Our Ref: P/47/11/

28th July 2011

Single storey extensions
52 East Front Road Pagham

Thank you for your internet comments made on 27th July 2011 and recorded as follows:

BASEMENT PLAN

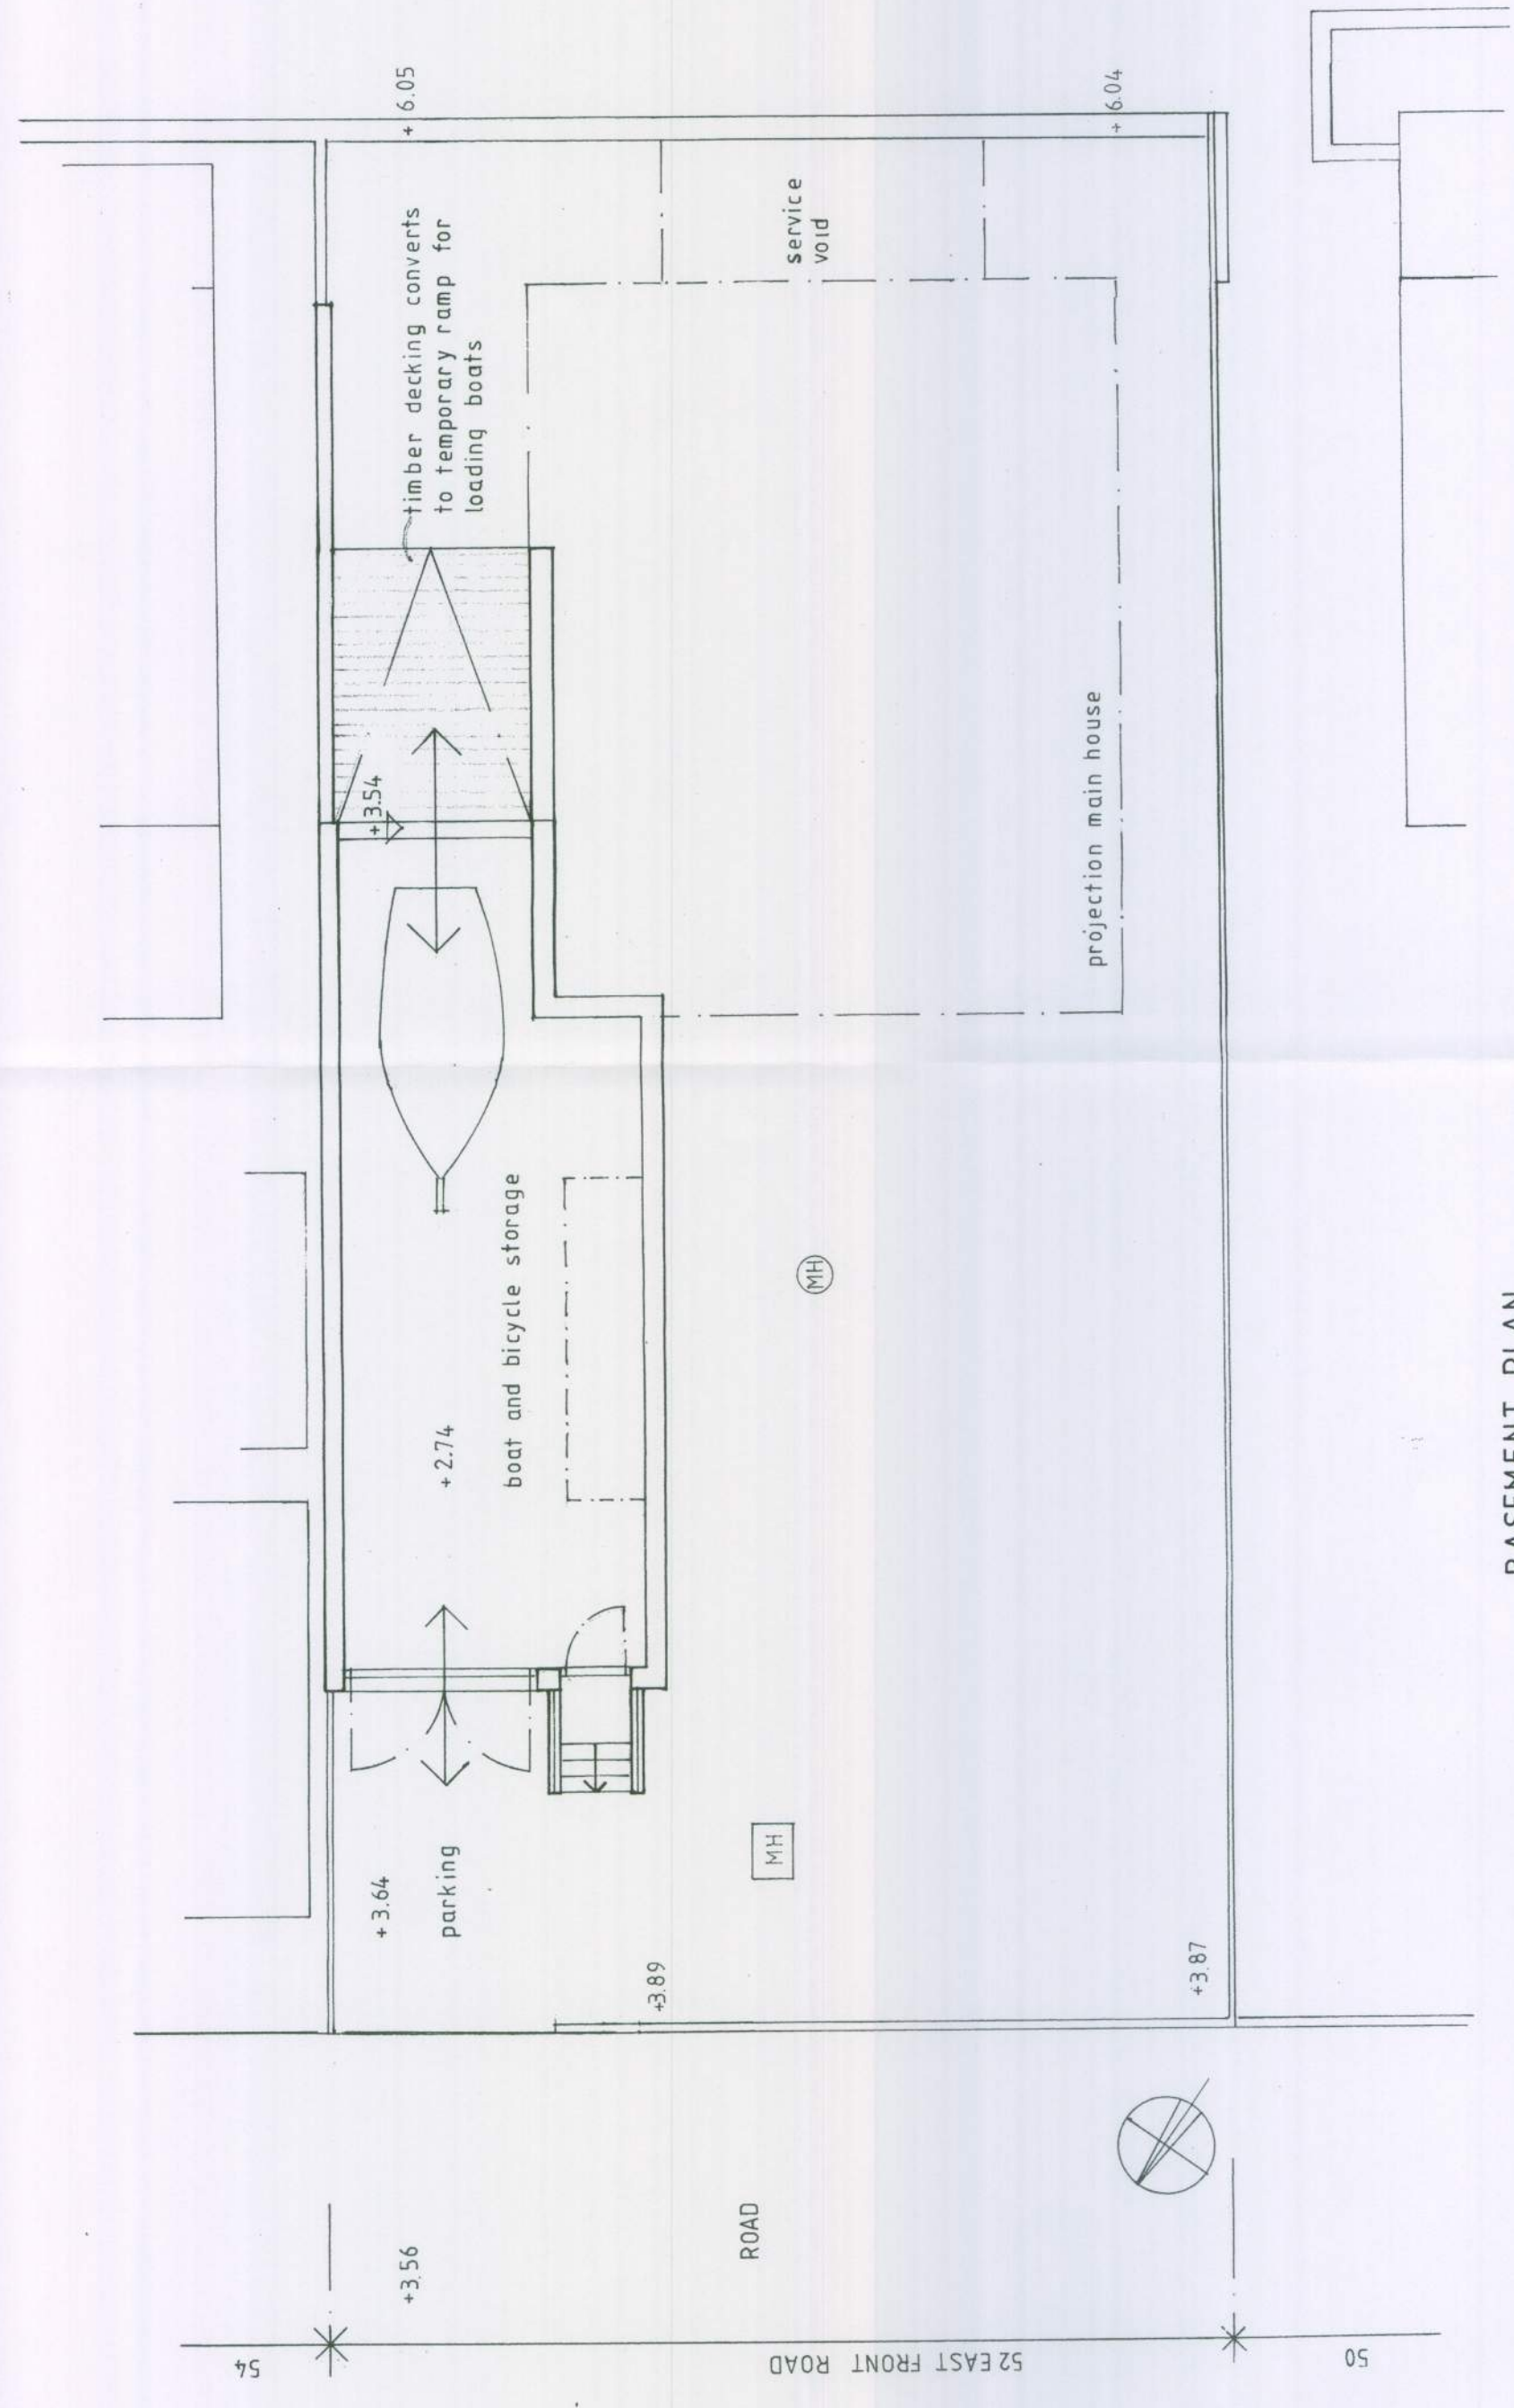
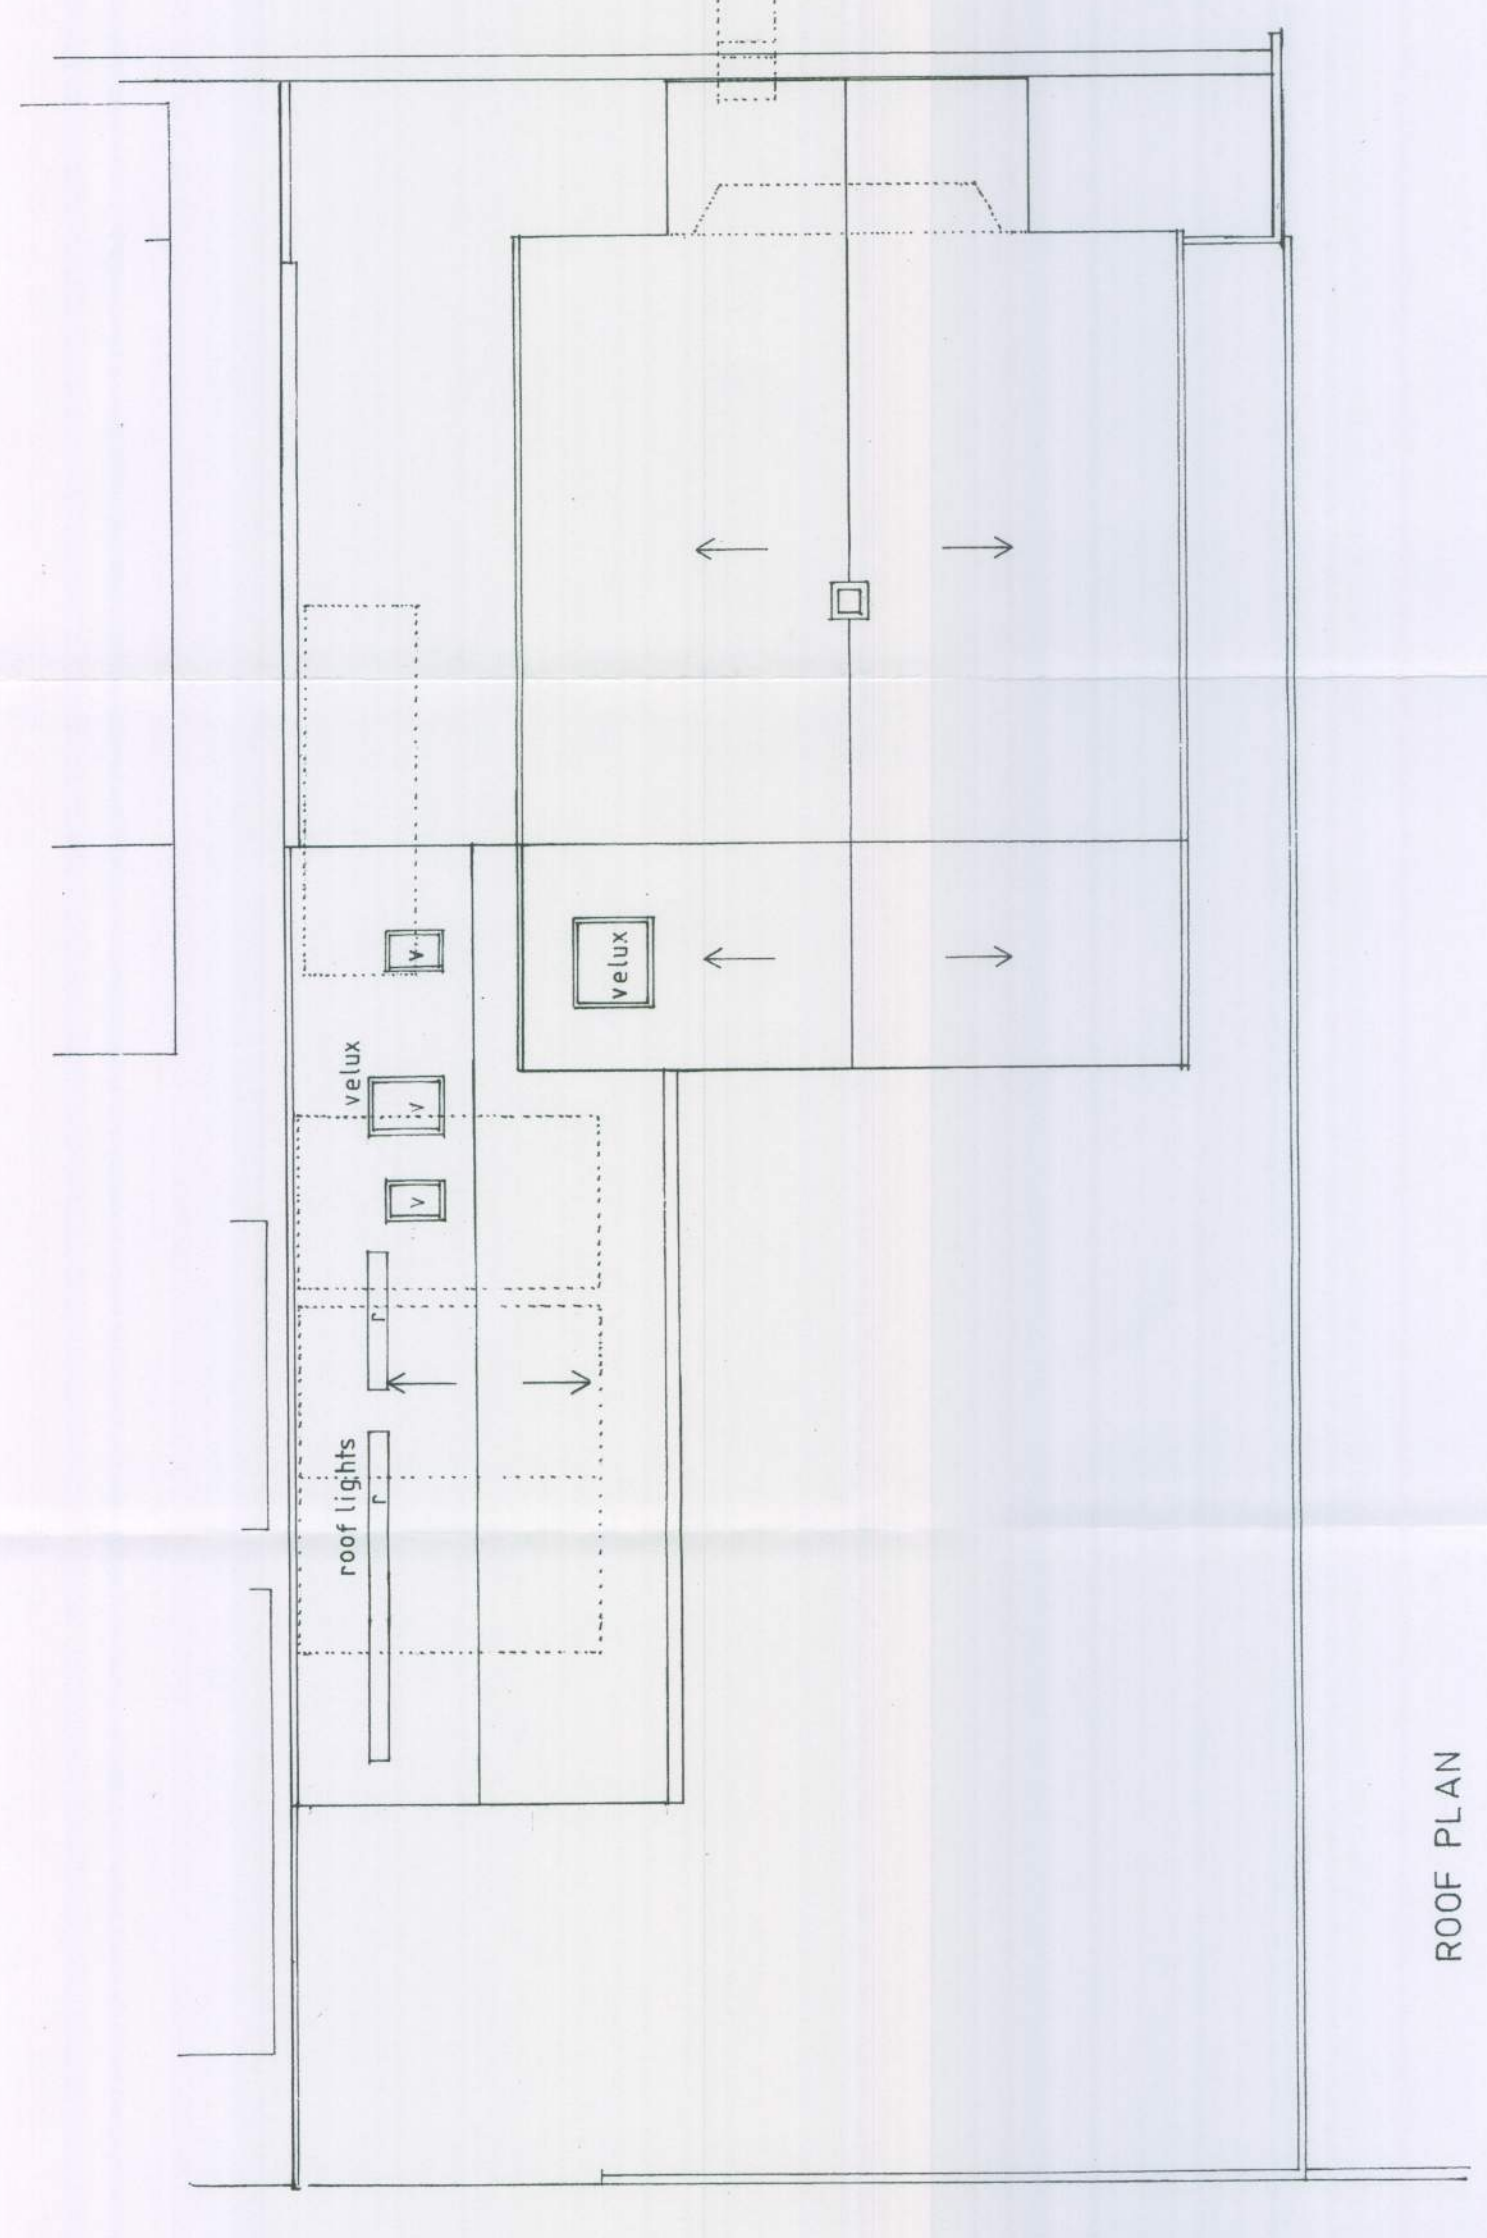
The prospect of engineering a very large excavation in order to accommodate a proposed underground room was viewed as particularly contentious from the point of potential extreme prejudice to dwellings adjacent where existing foundations systems would be put at risk of shingle subsidence and consequential collapse.
